WEST SUSSEX COUNTY COUNCIL CONSULTATION

TO:	Arun District Council FAO: Mr S Davis
FROM:	WSCC - Highways Authority
DATE:	1 June 2021
LOCATION:	Sunny Mead Farm North End Road Arundel BN18 0DL
SUBJECT:	Y/57/21/PL Demolition of existing dwelling and outbuildings and erection of 5 dwellings comprising 2 No 4 bed houses, 3 No 3 bed house (resubmission following Y/33/20/PL). This site is in CIL Zone 3 & is CIL Liable as new dwellings.
DATE OF SITE VISIT:	Site known to officer
RECOMMENDATION:	Advice / More Information
S106 CONTRIBUTION TOTAL:

DRAWING	SCALE
Site Plan	1:100 @A1

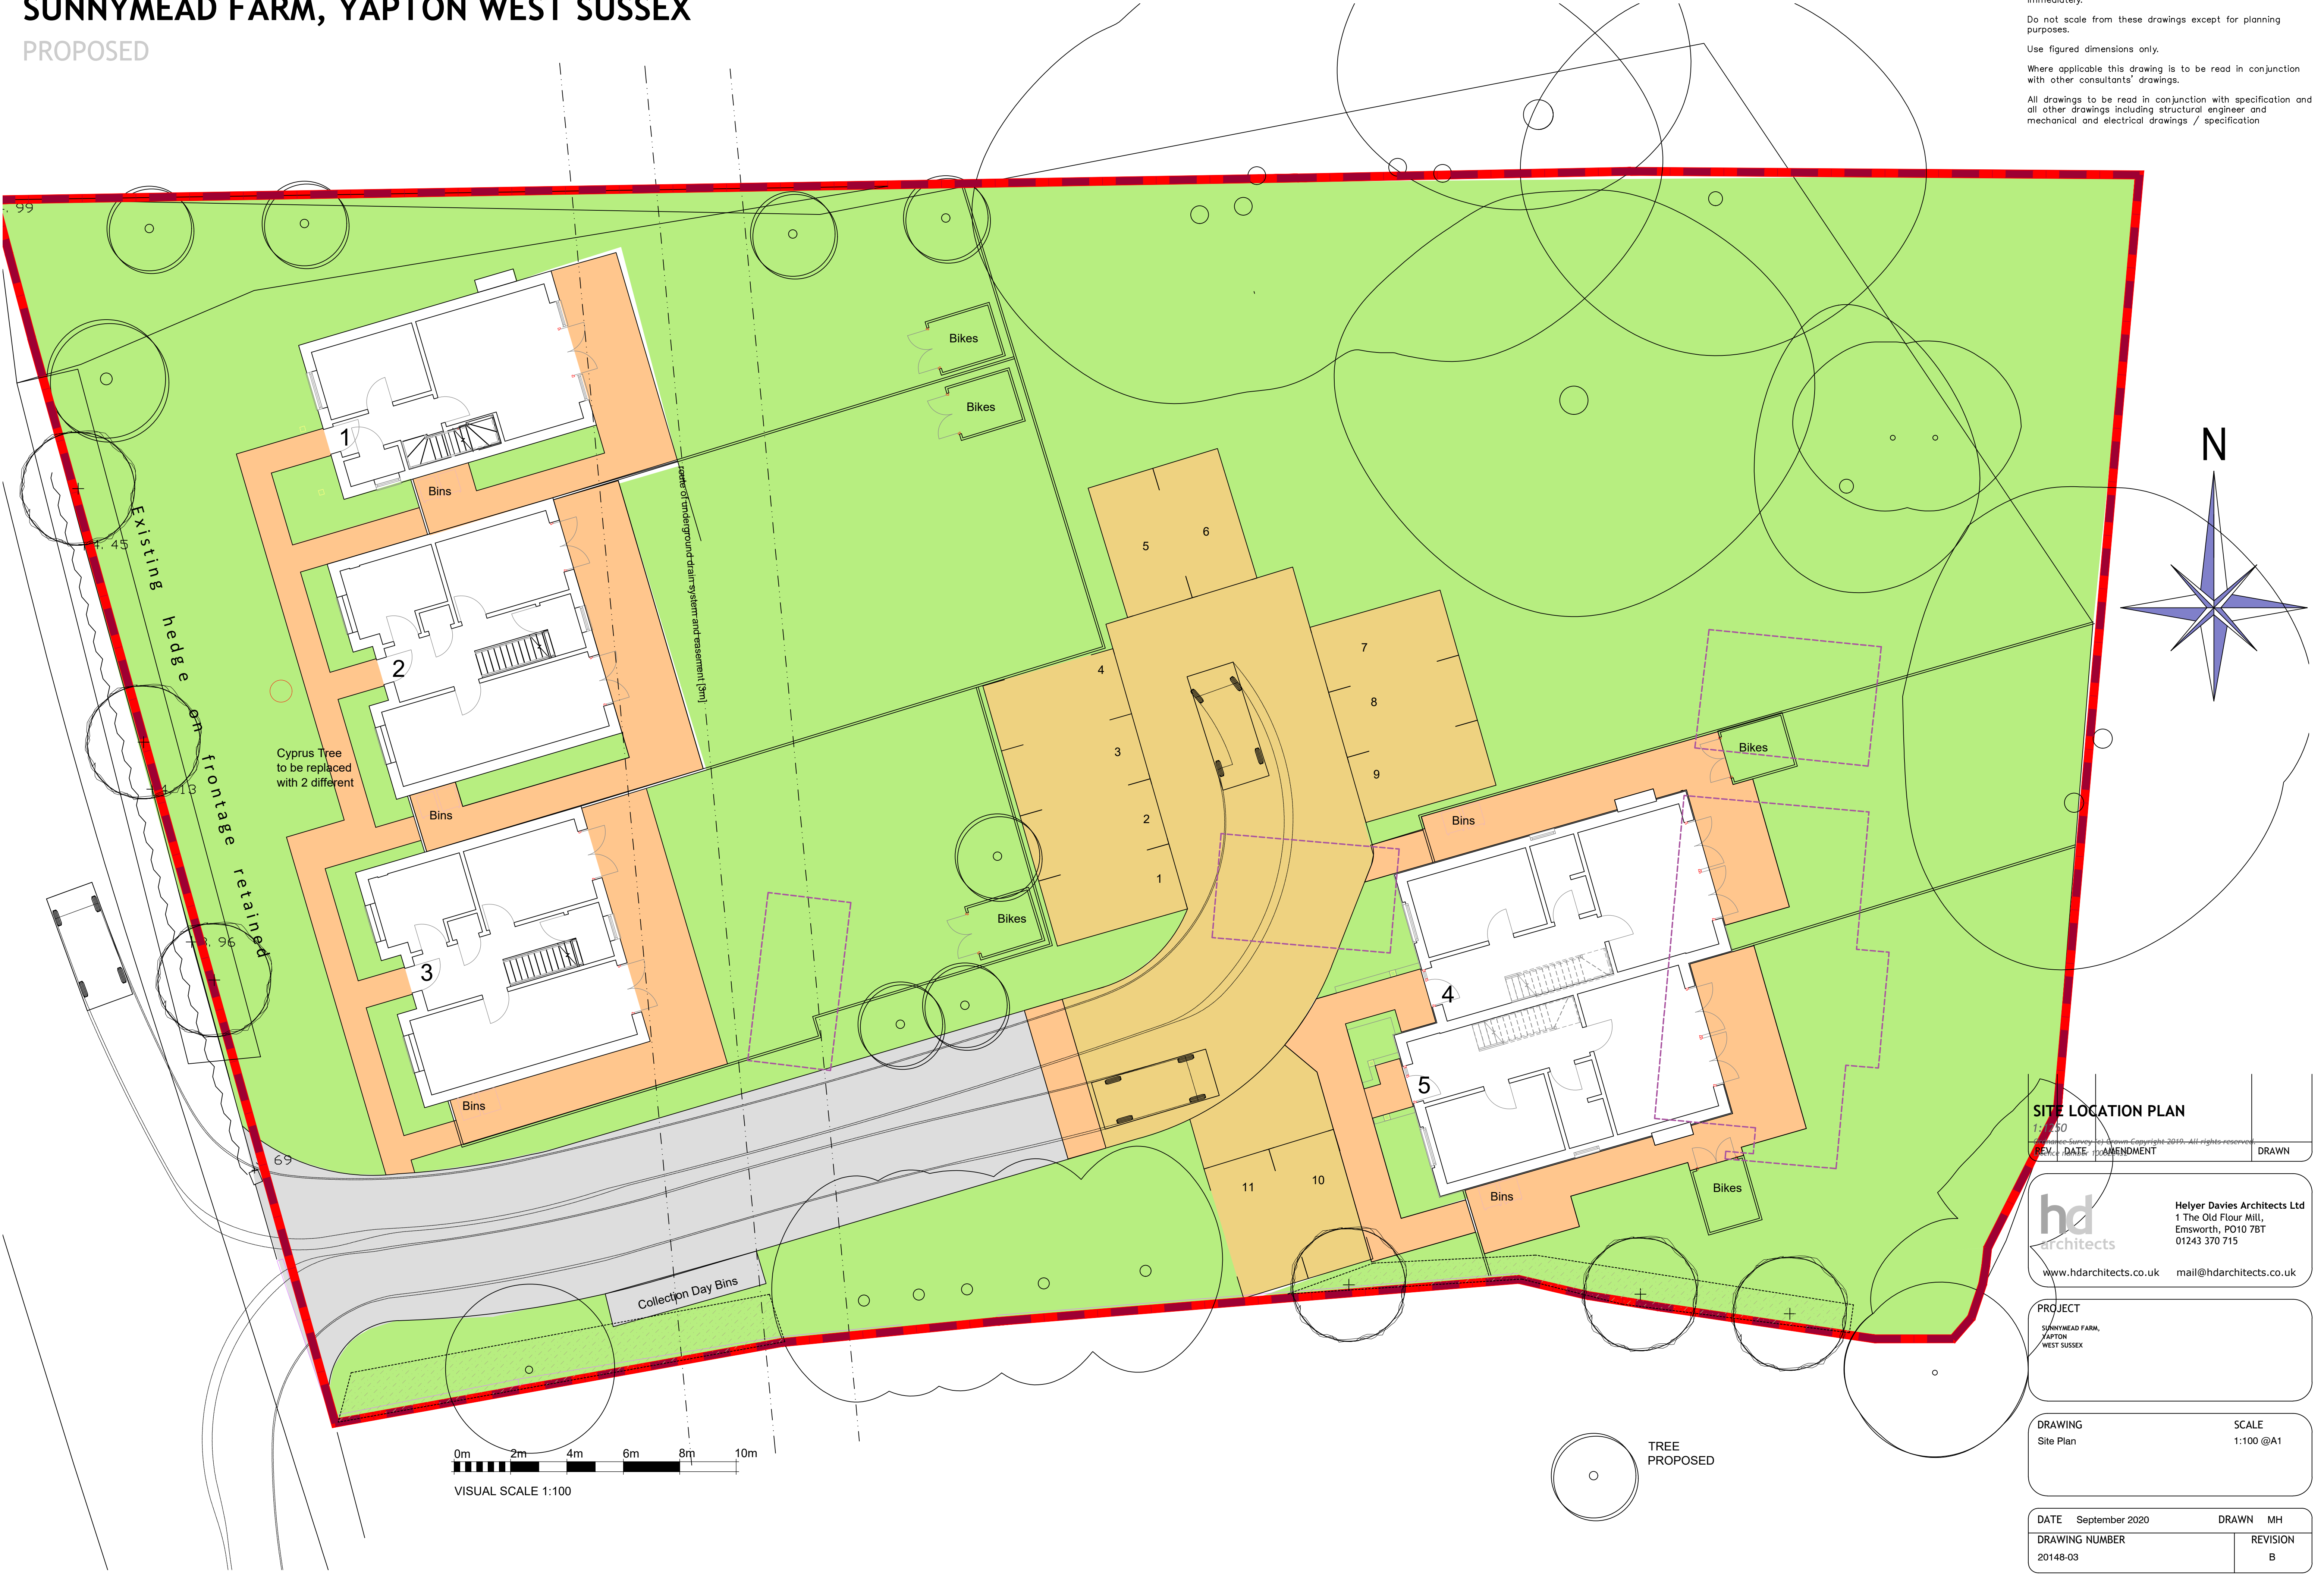
11 parking spaces are proposed. The LHA would raise no concern to this amount. It appears that there is adequate space for all spaces to be accessed. Active charging points for electric vehicles should be provided at a minimum of 20% of all parking spaces with ducting provided at all remaining spaces where appropriate to provide 'passive' provision for these spaces to be upgraded in the future.

It appears that refuse collection will take place from North End Road with bin storage being provide towards the front of the site, so there is no turning head within the site; however given the high number of delivery vehicles such as food delivery's, couriers etc consideration needs to be given to how a vehicle entering this site would turn and exit in forward gear, it would not be acceptable to reverse in from or out into the highway.
